Re: Duggers Towing

7001 San Pedro NE

Request for Permanent C.O. - Accepted Engineer's Stamp dated: 05-29-13 (D18D034)

Re: Duggers Towing, Grading and Drainage Plan
Engineer's Stamp Date 04-02-2013 (D-18/D034)

# G1

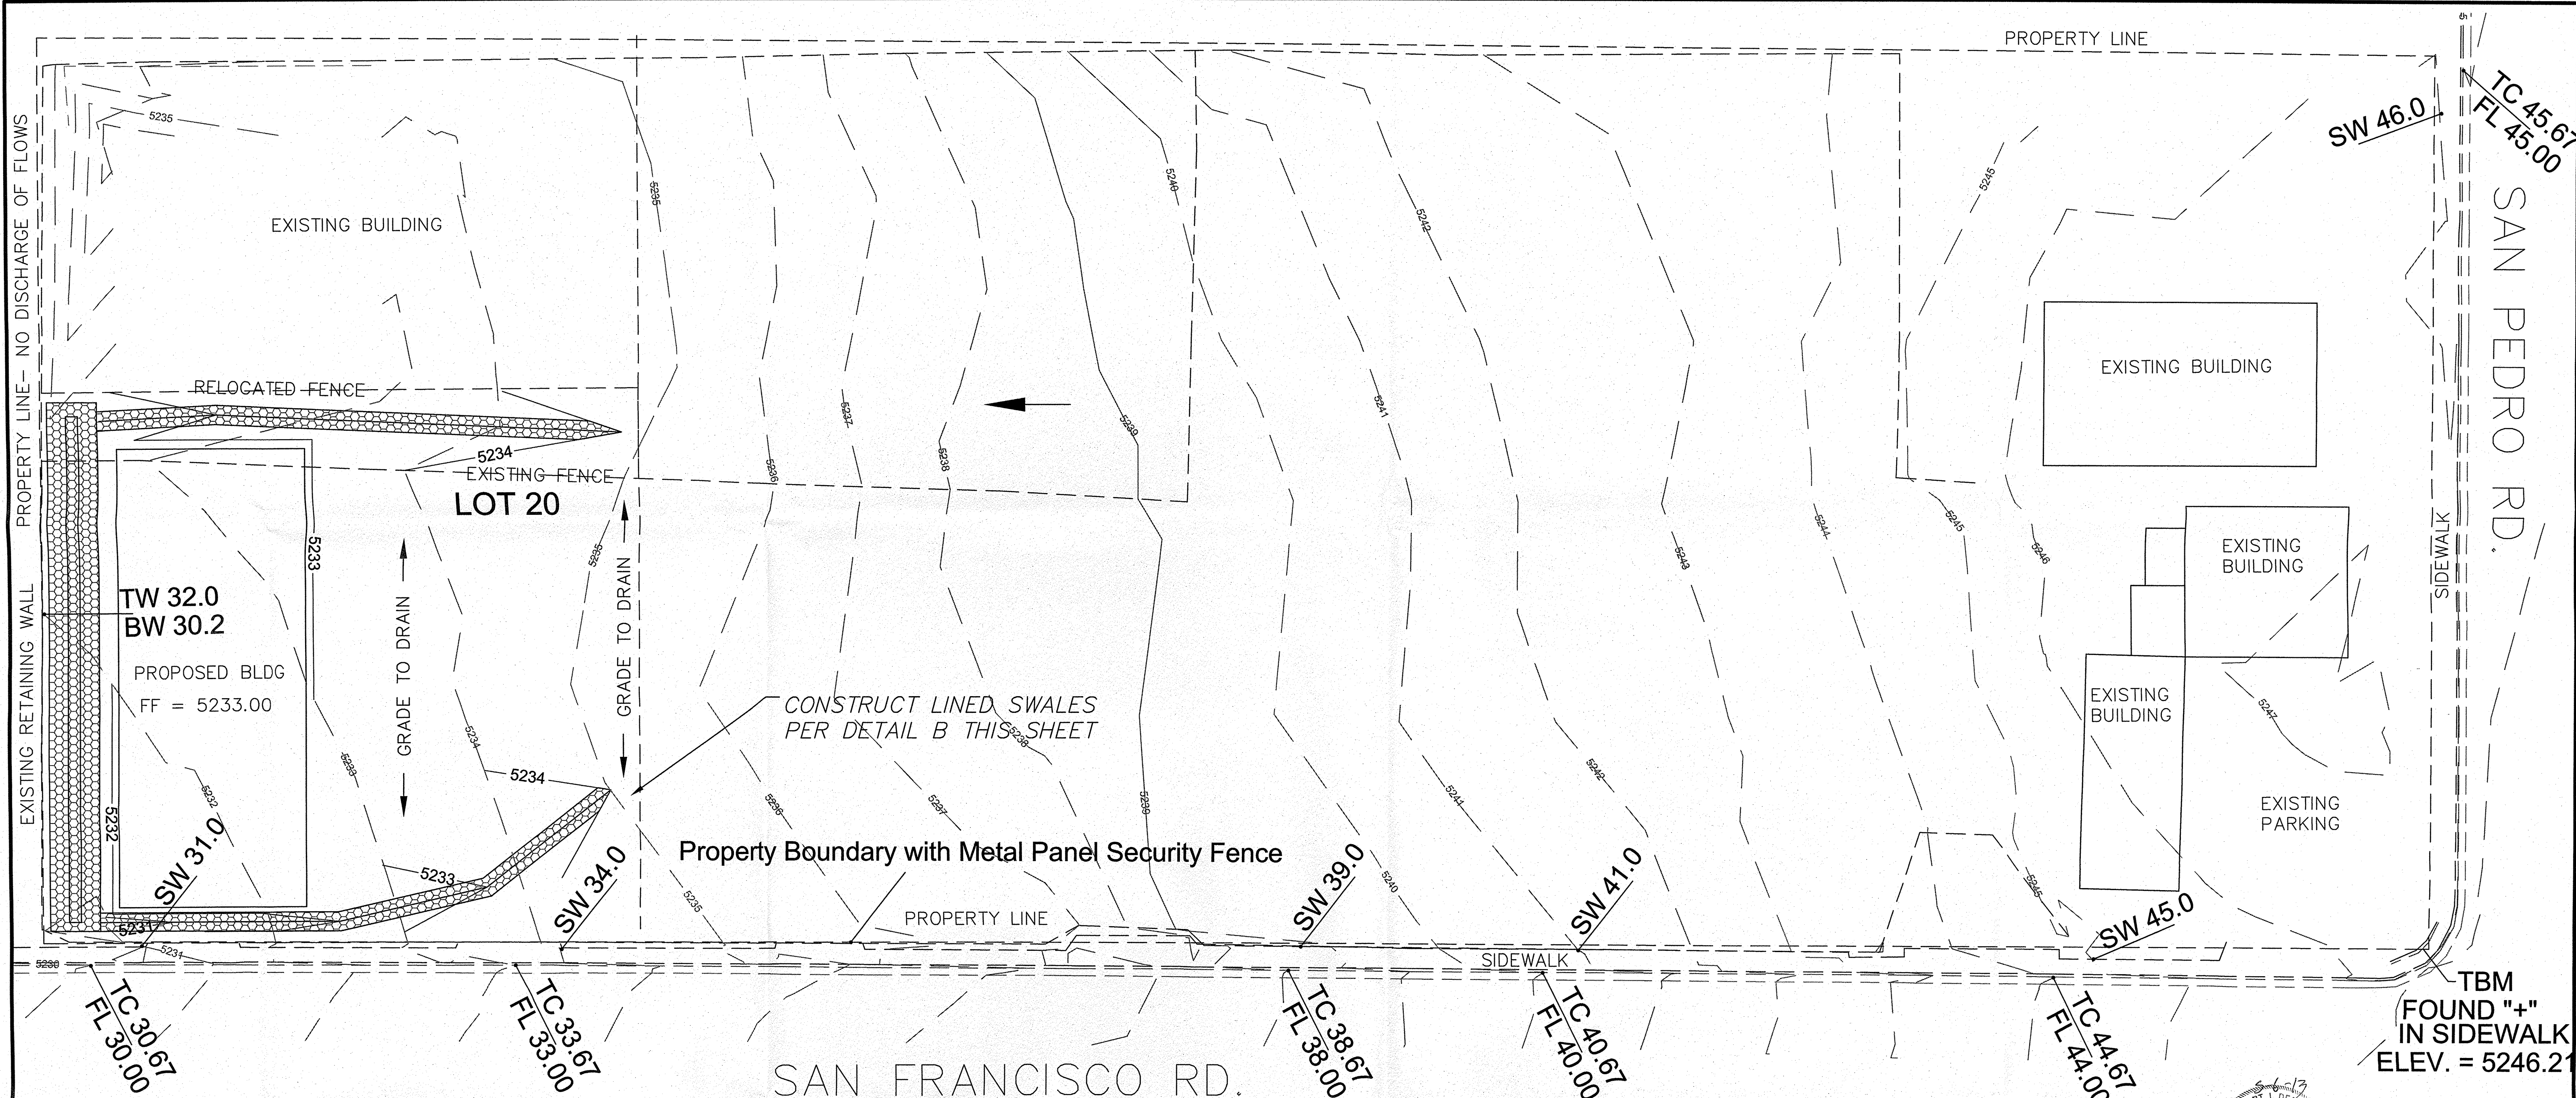
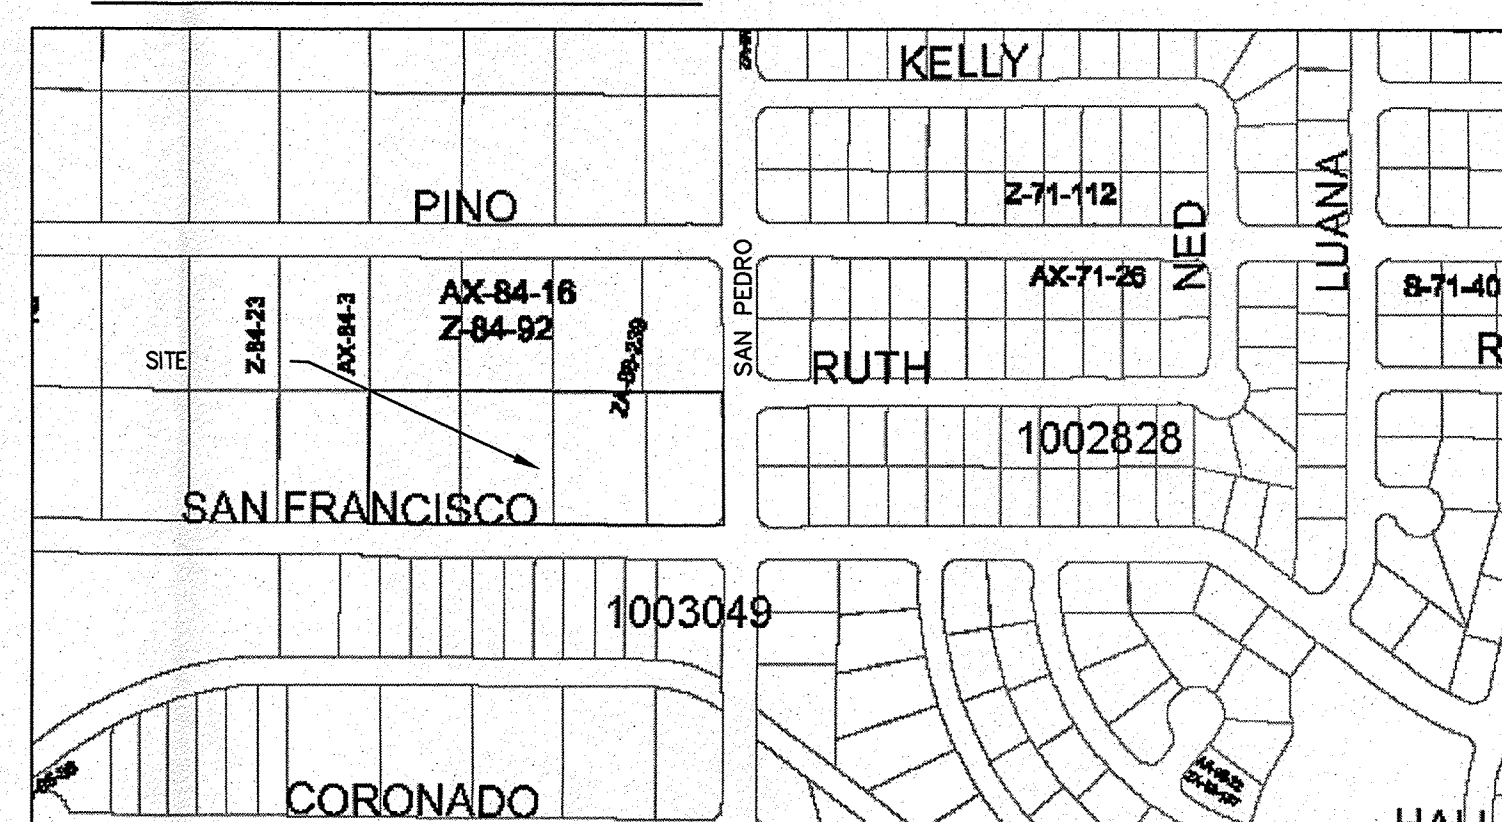
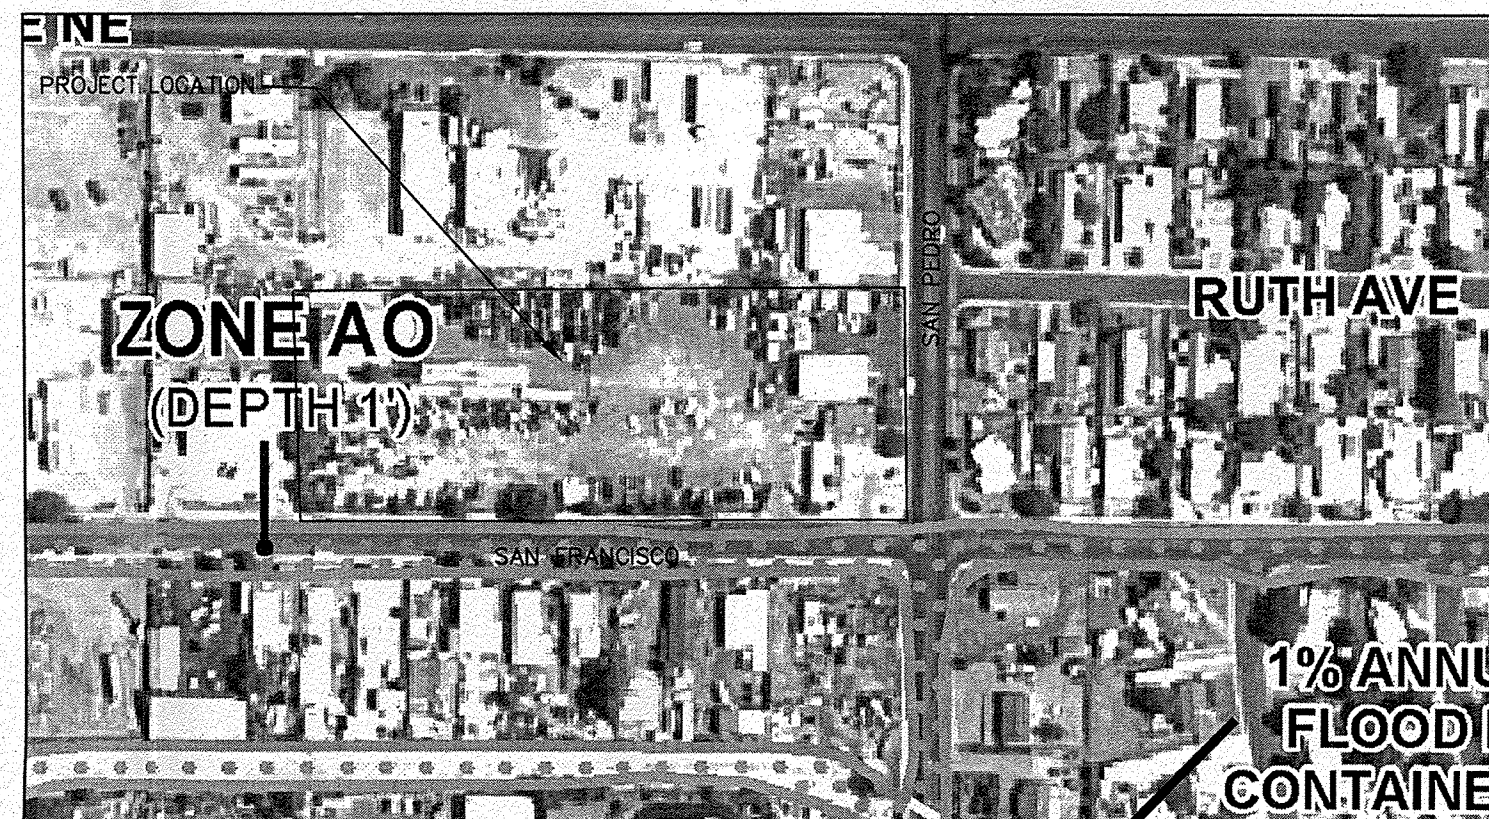
- Please quantify all off-site flows being received and show how these flows will leave the site.
- Provide additional spot elevations of the site interior as well as extend contours and show additional spots to the west of the property.
- Clarify the property boundaries; show all sidewalk, curb and gutter elevations and flowlines along San Francisco Drive.
- The proposed retention pond will be required to hold the full 10-day volume of developed and concentrated flows from the site; Hydrology suggests the implementation of a detention pond with ultimate discharge through a sidewalk culvert onto San Francisco Drive.
- How will the channelized flows be directed around the bends into the proposed pond without topping over?
- Will there be any parking requirements for the proposed building?
- Provide a benchmark designation on the grading plan.

The site is isolated from offsite flows by curb & gutter along San Pedro, San Francisco and Pino. Flows from adjoining private property immediately to the north are prevented by CMU walls, corrugated metal security fence, and existing grading. Additionally, an existing metal-panel security fence along the south and west side property line prevents discharge of flows along the west and south sides of the site. The revised drawing quantifies all off-site flows being received, and how these flows are routed to an on-site retention pond.

More detailed contouring is shown in the revised drawing, as well as extended contours and spots to the west. (Private property access was not granted to the west, but we have provided spot elevations where we were able to legally acquire topography)

The property boundaries have been clarified and the requested elevations along San Francisco are shown.

The design hydrology and retention pond design have been revised to retain the 10-day volume, no discharge through sidewalk culvert is planned for the purpose of storm water quality.

The pond has been extended to remove the bends and any possibility of topping over.

A project benchmark is shown at the corner of San Pedro and San Francisco.

G1

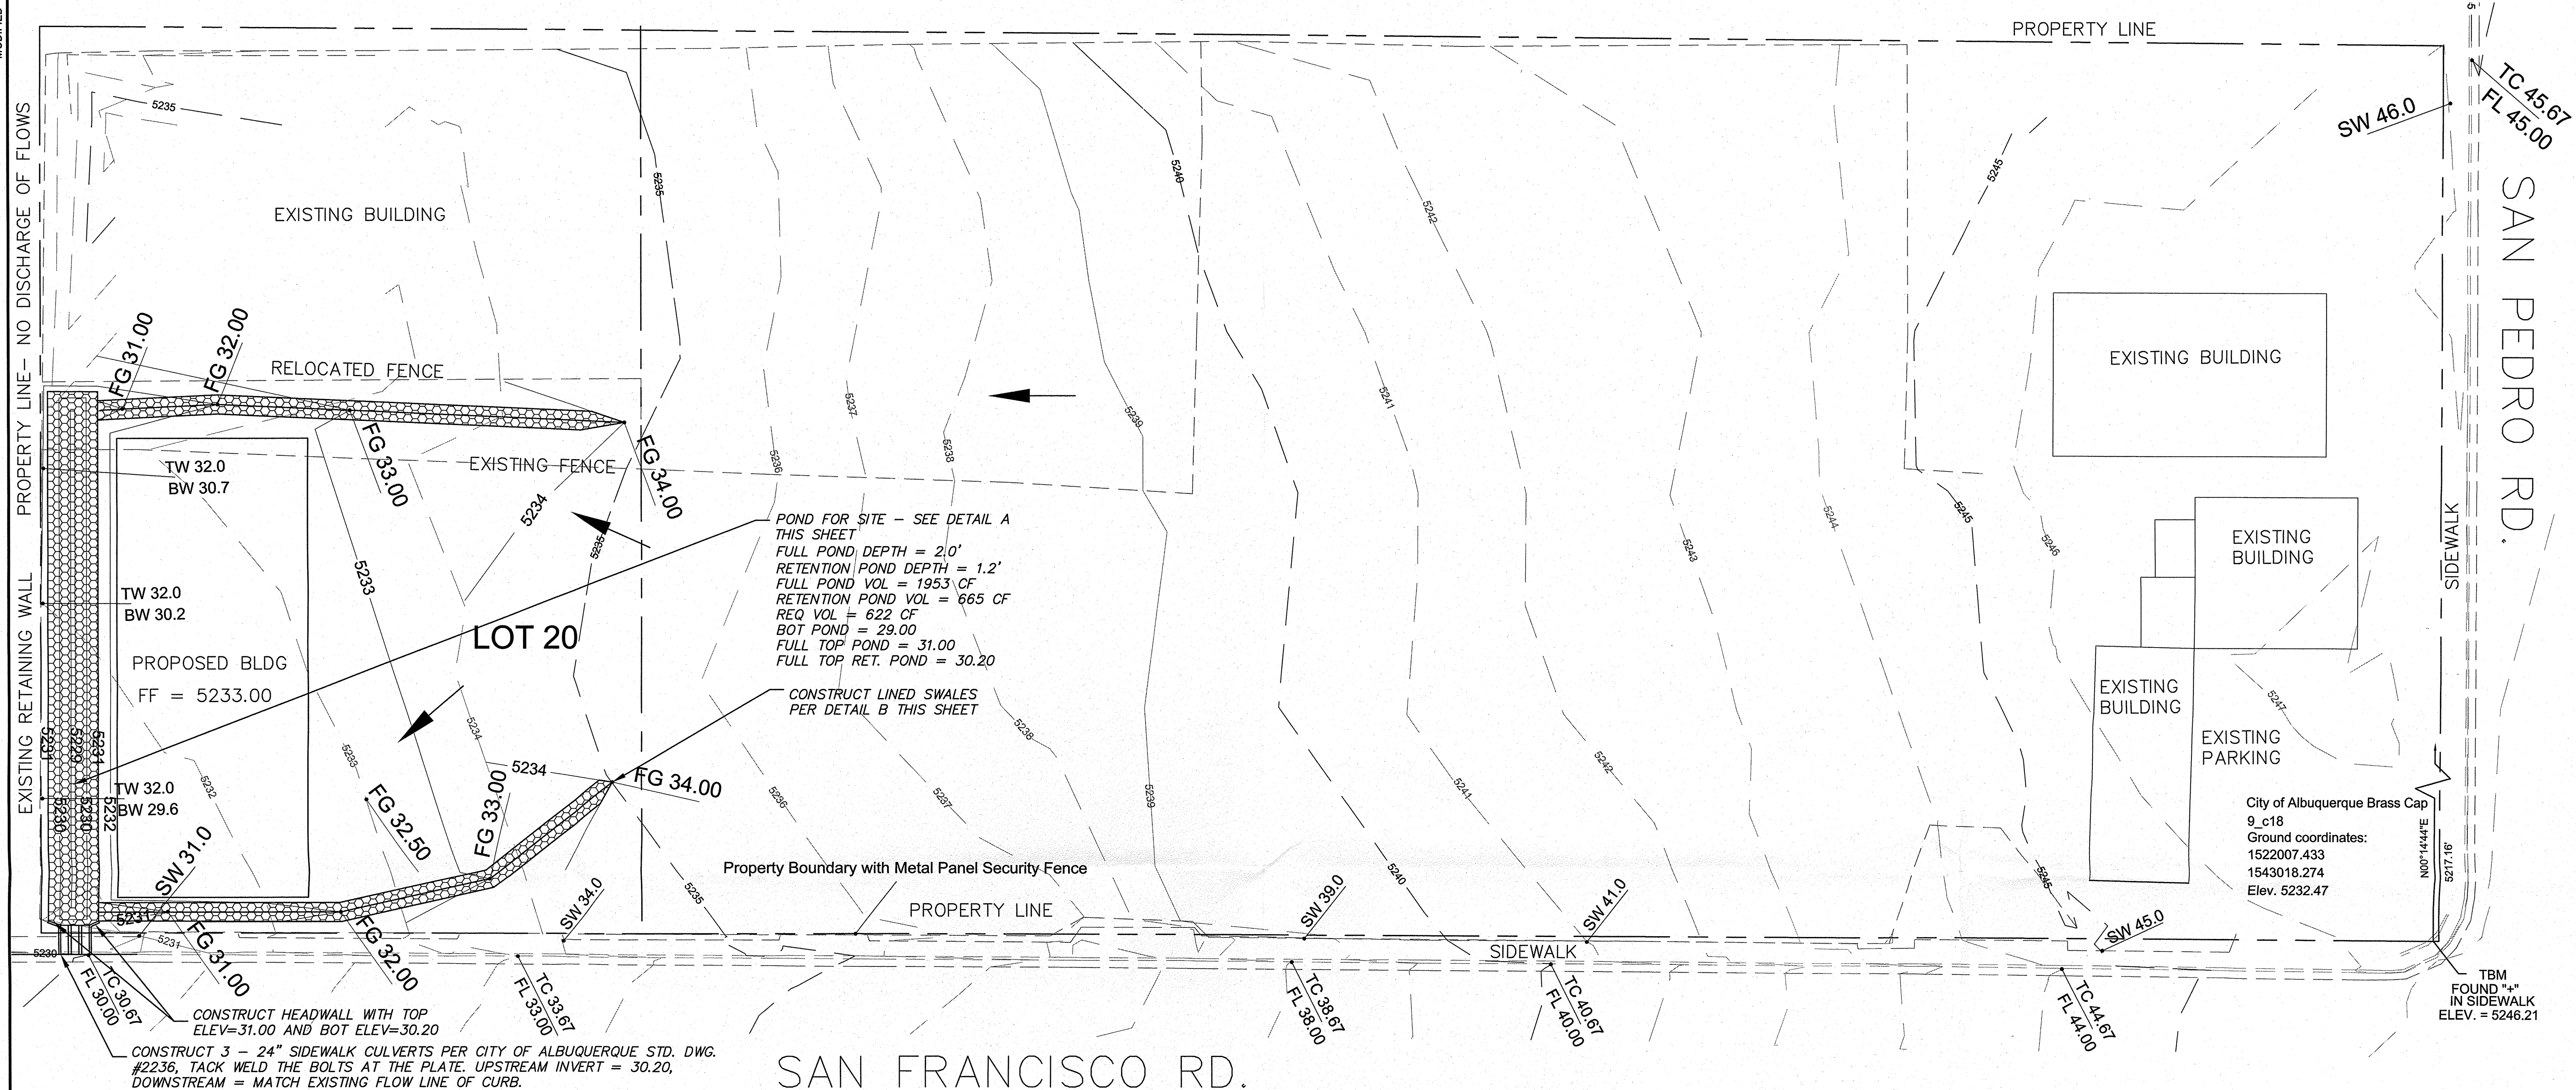
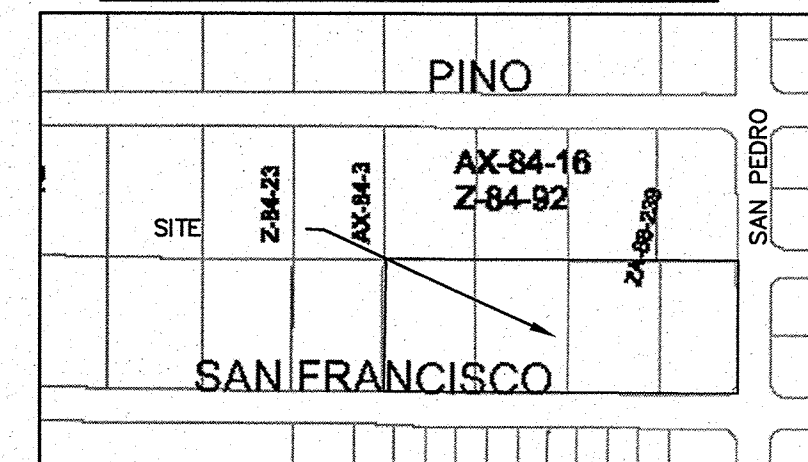
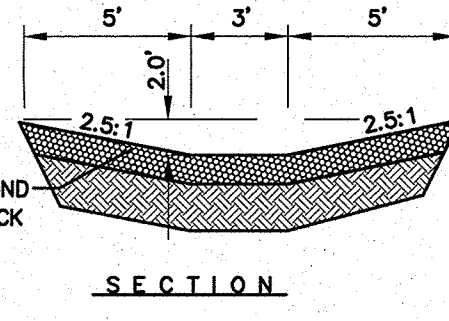
- _ower the pond so we would retain the developed volume. The invert of the sidewalk culverts and the bottom of the pond are the same elevation.
- 2 Change the property line to a thicker solid line or phantom for clarification.

- 3 Extend the sidewalk culvert 2' passed the property line. Add a note to the sidewalk culverts to "TACK WELD THE BOLTS AT THE PLATE".
- 4_ Provide sidewalk culvert capacity calculation.

- 5 Increase the txt size for the drainage calculations on the plan.
- 6_ Can you redesign the pond to make it a retention/detention pond to limit the discharge so you would only need 2-2' sidewalk culverts? Possibly the top of the pond would be at 31.50 or 32.00 and the bottom may at 29.20 and discharge point at 30.20. Provide a headerwall at the back of the inlet (with the top at 31.5 or 32.0) and opening sized to the sidewalk culvert dimensions.
